# **OXFORDSHIRE COUNTY COUNCIL'S RESPONSE TO CONSULTATION ON THE FOLLOWING DEVELOPMENT PROPOSAL**

**Application no:** 21/03268/OUT

**Proposal:** Outline planning permission (all matters reserved except for access) for the erection of buildings comprising logistics (Use Class B8) and ancillary Office (Use Class E(g)(i)) floorspace; construction of new site access from the B4100; creation of internal roads and access routes; hard and soft landscaping including noise attenuation measures; and other associated infrastructure

**Location:** NW Of Baynards House, Ardley

Drawing Number  
**S1299-P-12**

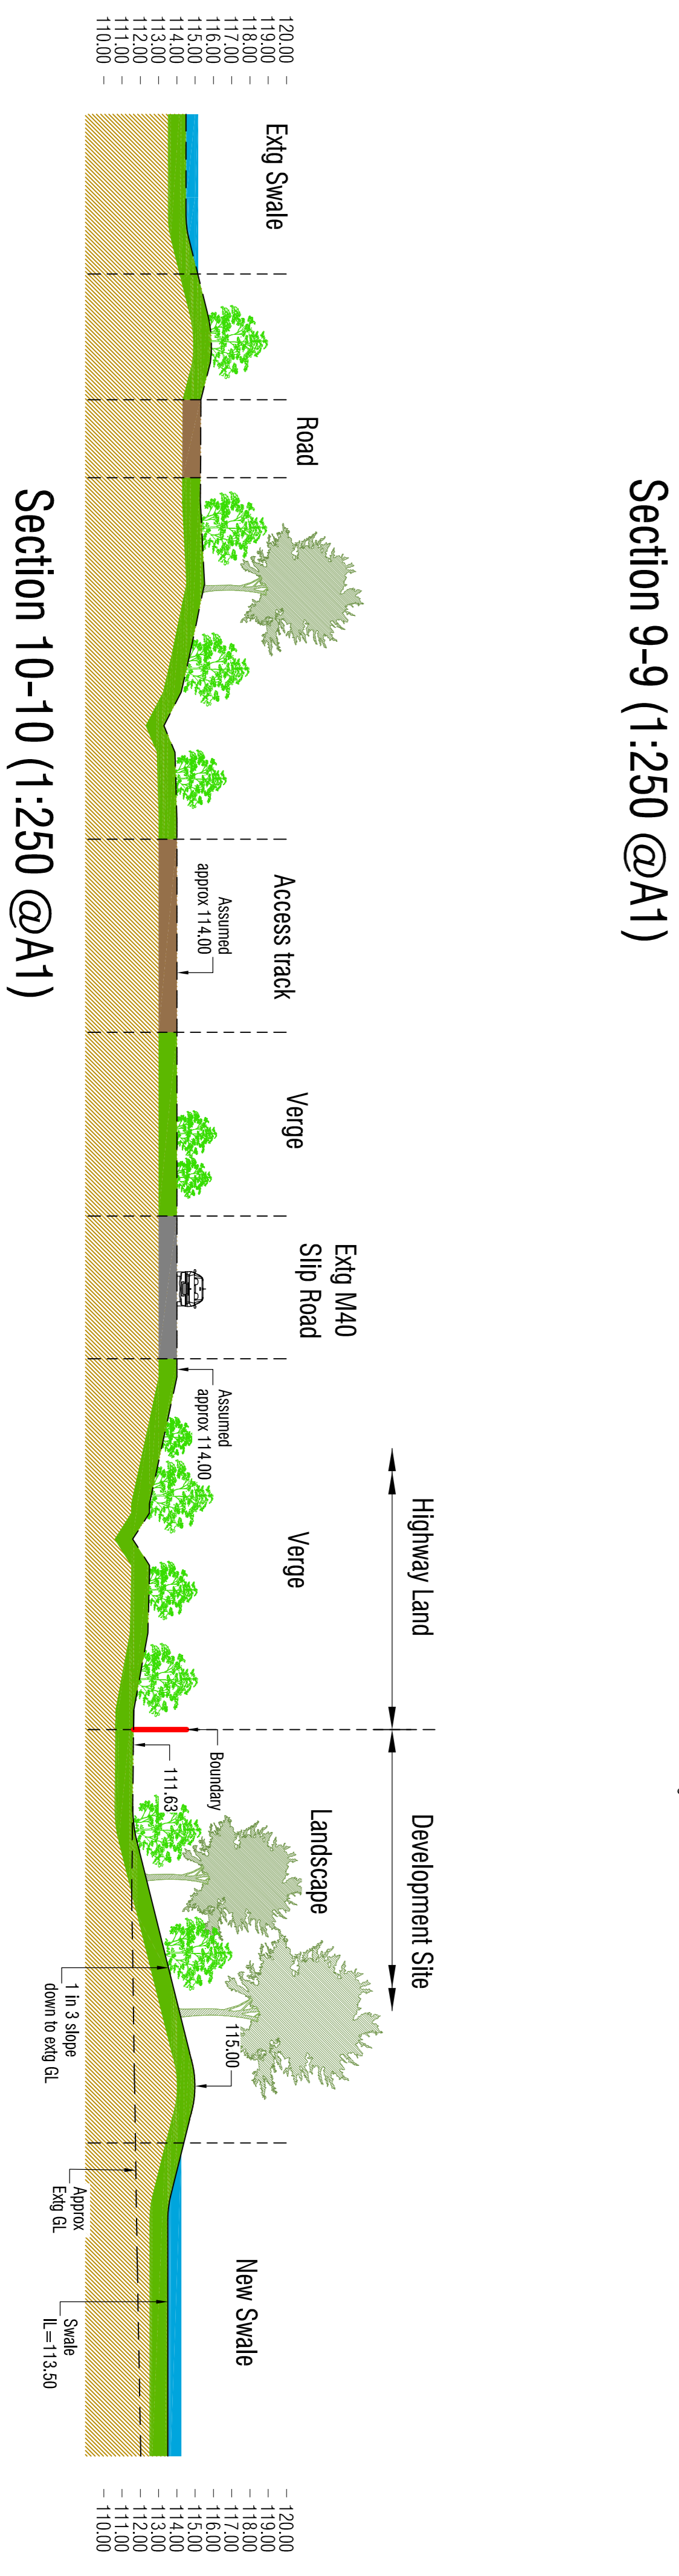
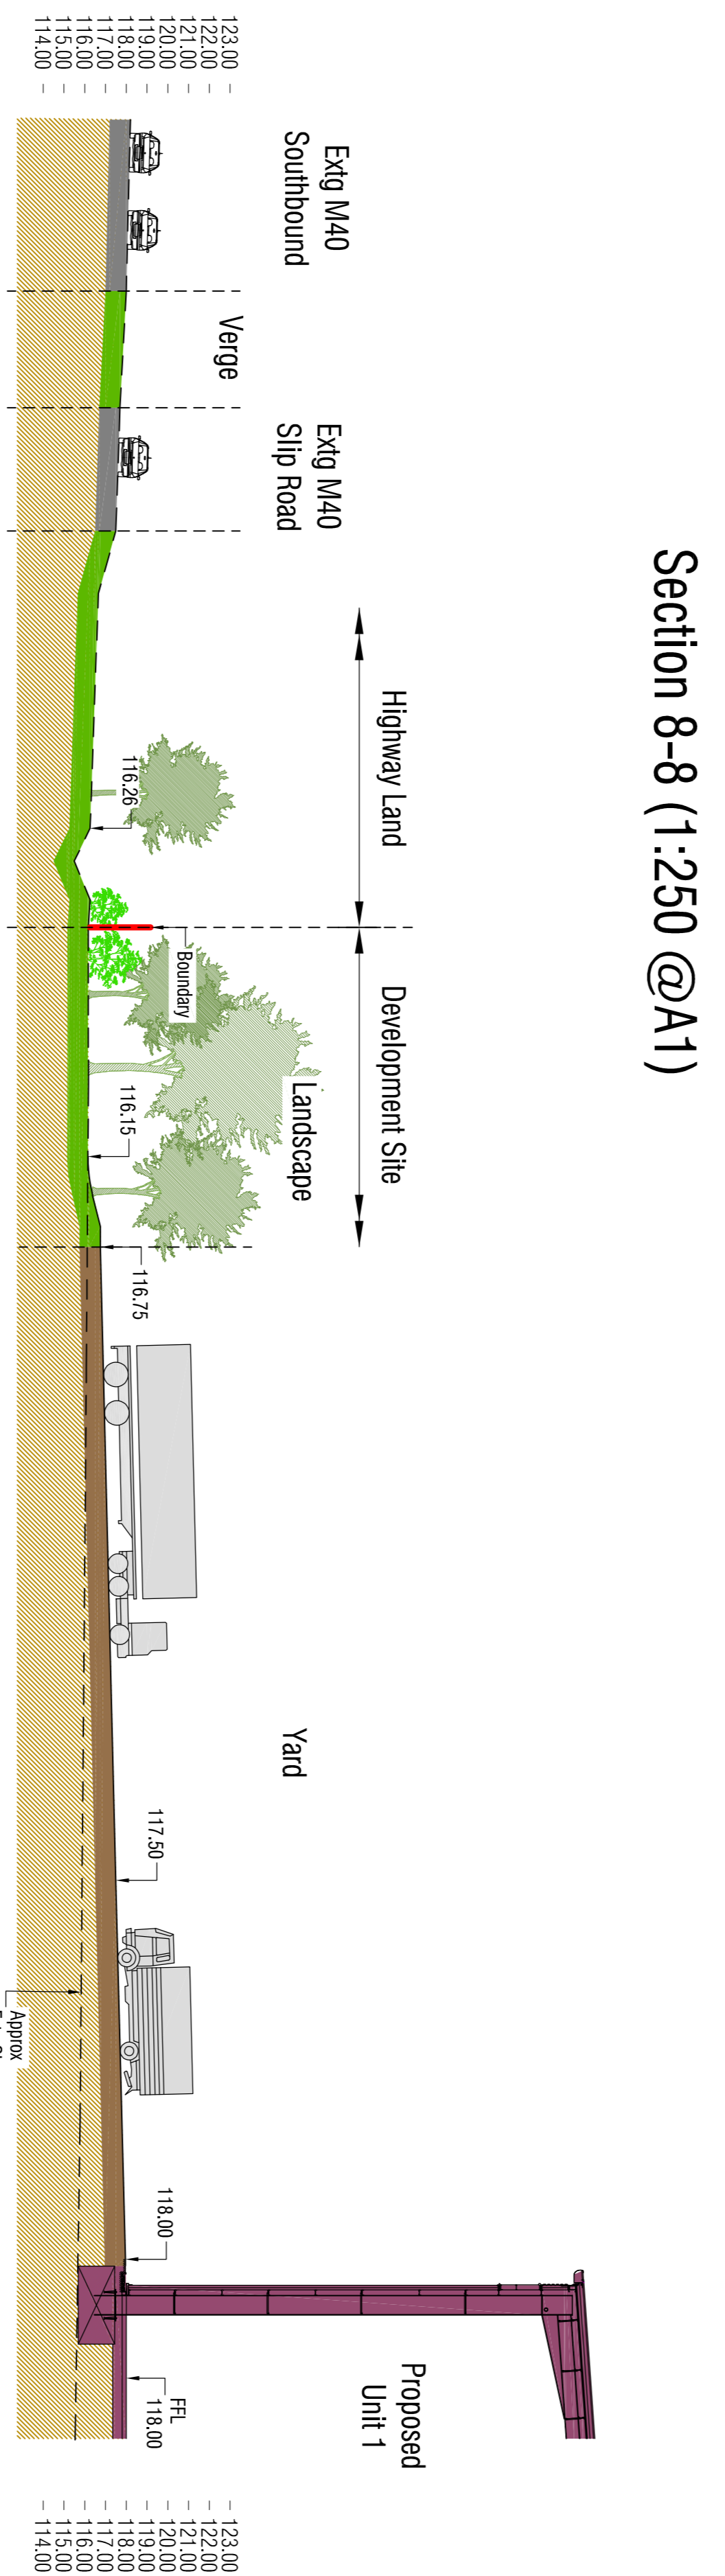
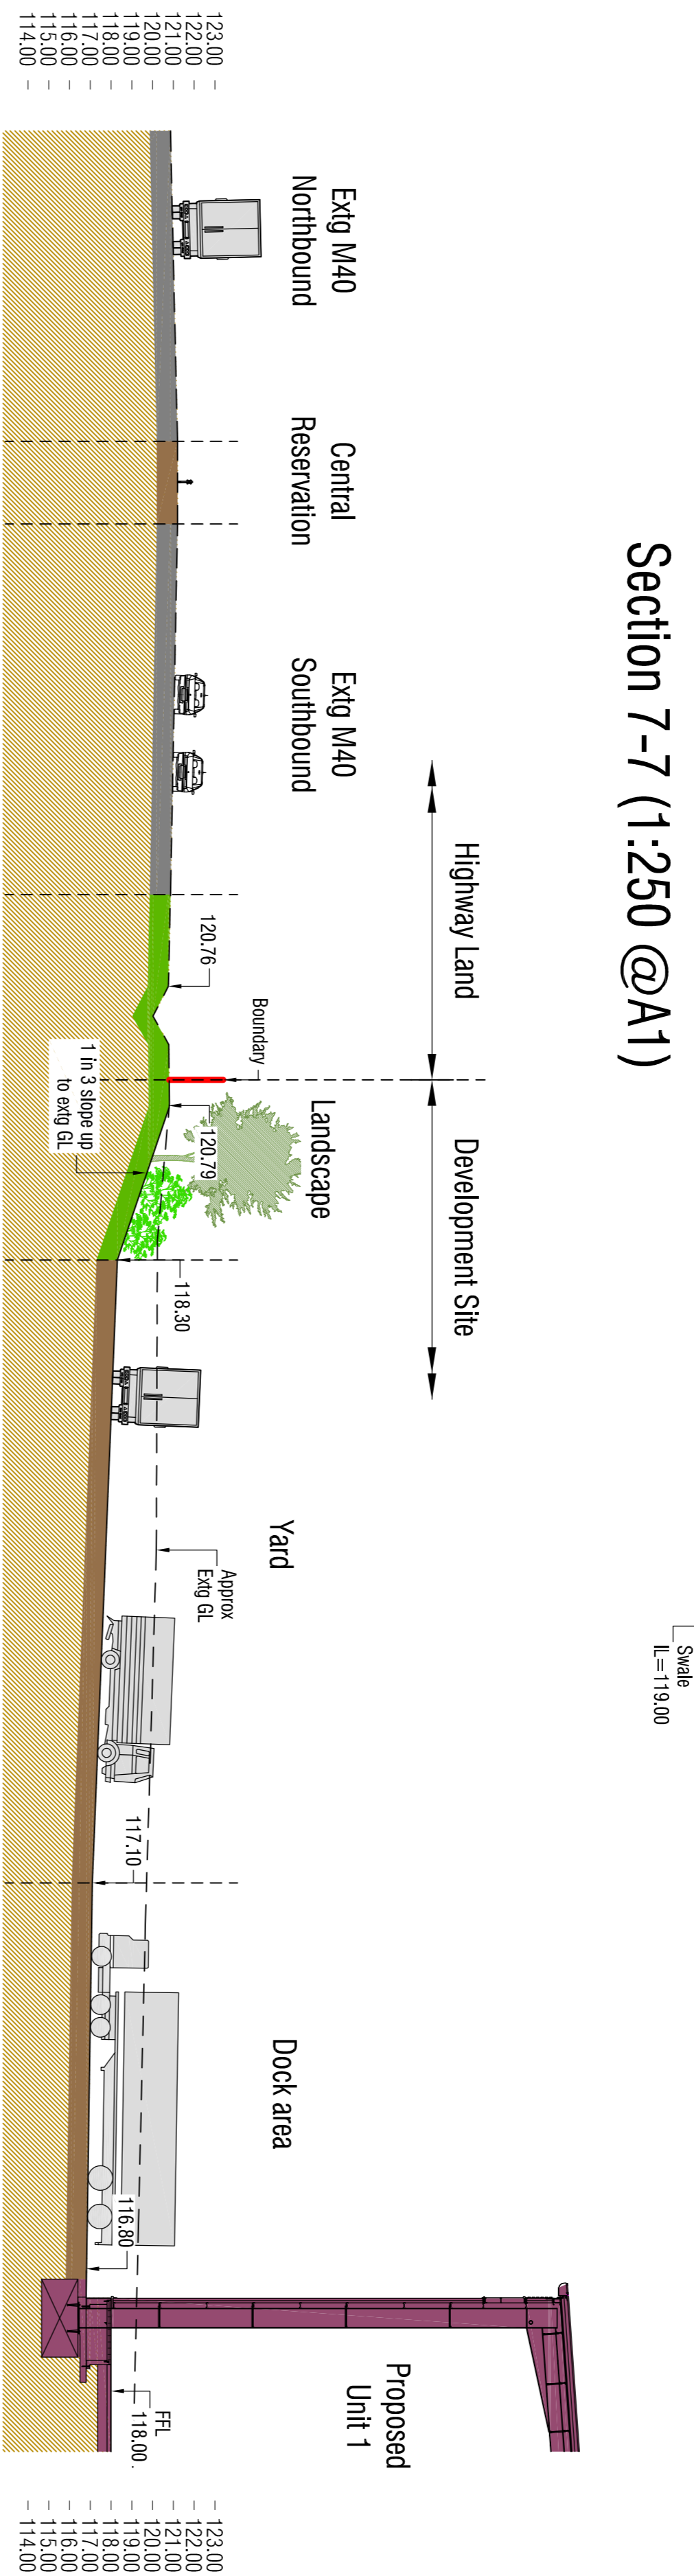
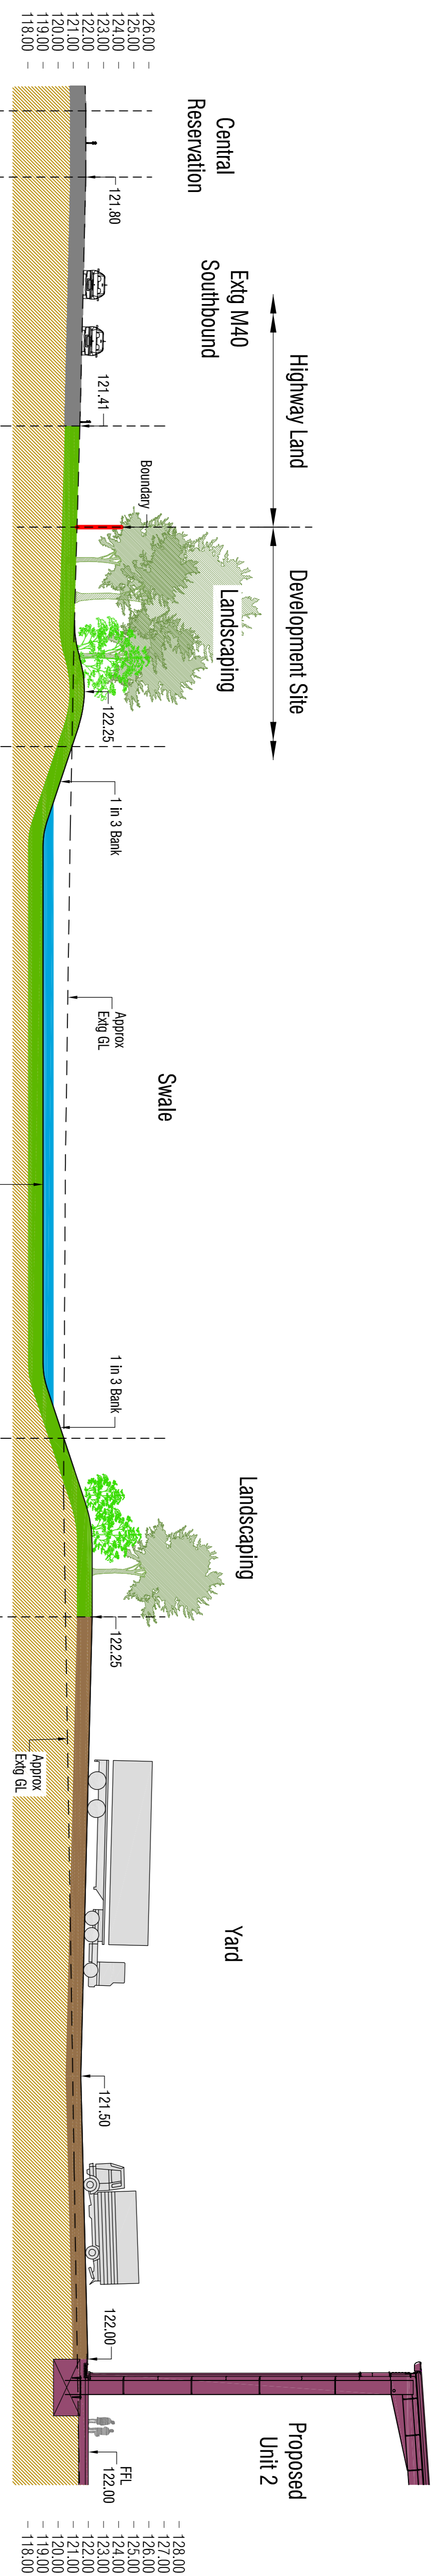
Where the shared use route runs along the site frontage, it would be preferable for it to run within the site rather than adjacent the carriageway, as it would only be accessing the site. To provide a direct route to the western building in the indicative masterplan, I recommend a safe crossing point part way along the access road – this could be a parallel crossing if the access road is subject to a 30mph speed limit, or combined with some sort of traffic calming feature such as a refuge.

The two bus stop locations proposed, one within each part of the development, are well located for the development. They are however located off-line of a Bicester to Brackley bus route – to serve them will increase the overall bus journey time and lessen the attractiveness of the bus for passengers travelling that are not going to the development. This is particularly the case for the western side of the development. However, locating the stops on the B4100 would increase the walking distance to the development and lessen the attractiveness of bus for passengers travelling to the development. On balance, the proposed stop locations are probably the best within the constraints of the current development proposal. If the layout of the development is revised, it would be beneficial to investigate whether more efficient stop locations can be found, particularly for the western part of the site, without the stops becoming too remote from the building entrances they serve.

JOB TITLE LAND AT M40 JUNCTION 10		CLIENT ALBION LAND	
DRAWING TITLE WESTERN SITE ACCESS GENERAL ARRANGMENT			
SCALE 1:500@A1	DRAWN BY RM	DATE 03/08/21	DRAWING No 17213-09-GA
			REVISION P0

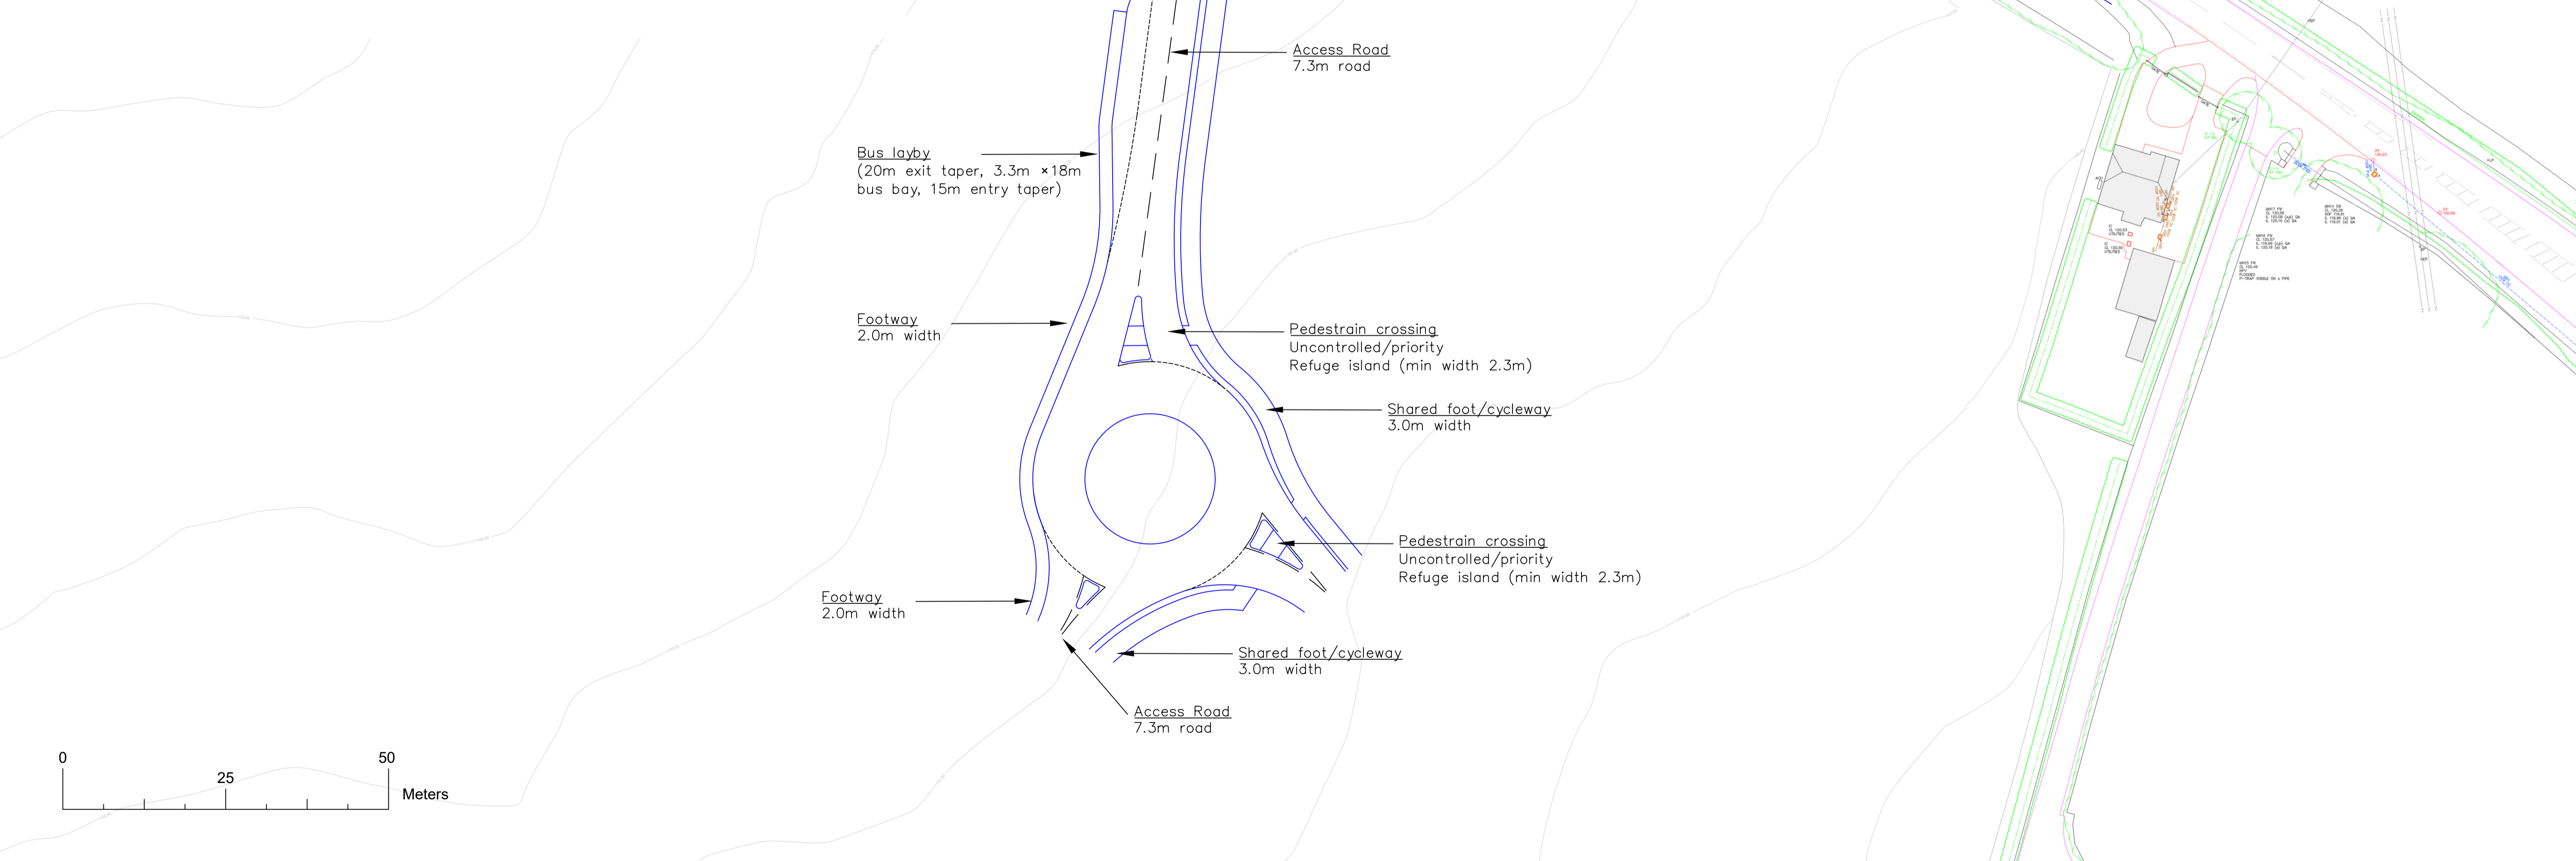
A new roundabout junction is proposed onto the B4100. A drawing has been provided showing how this meets DMRB standards. However, OCC has concerns about the straightness of the approaches on the B4100, especially given the national speed limit. Experience of similar layouts of recently constructed roundabouts on high speed roads has shown that some drivers fail to appreciate the roundabout until the last minute, leading to collisions or driving over the roundabout. Further work is needed to adjust the alignment of the B4100 on approaches. This is challenging due to the land on the northern side of the B4100 not being available. This has not been picked up in the Road Safety Audit provided, but OCC would welcome further discussions given their experiences elsewhere. Consideration could be given to a reduction in the speed limit along the site frontage extending to Baynards Green roundabout.
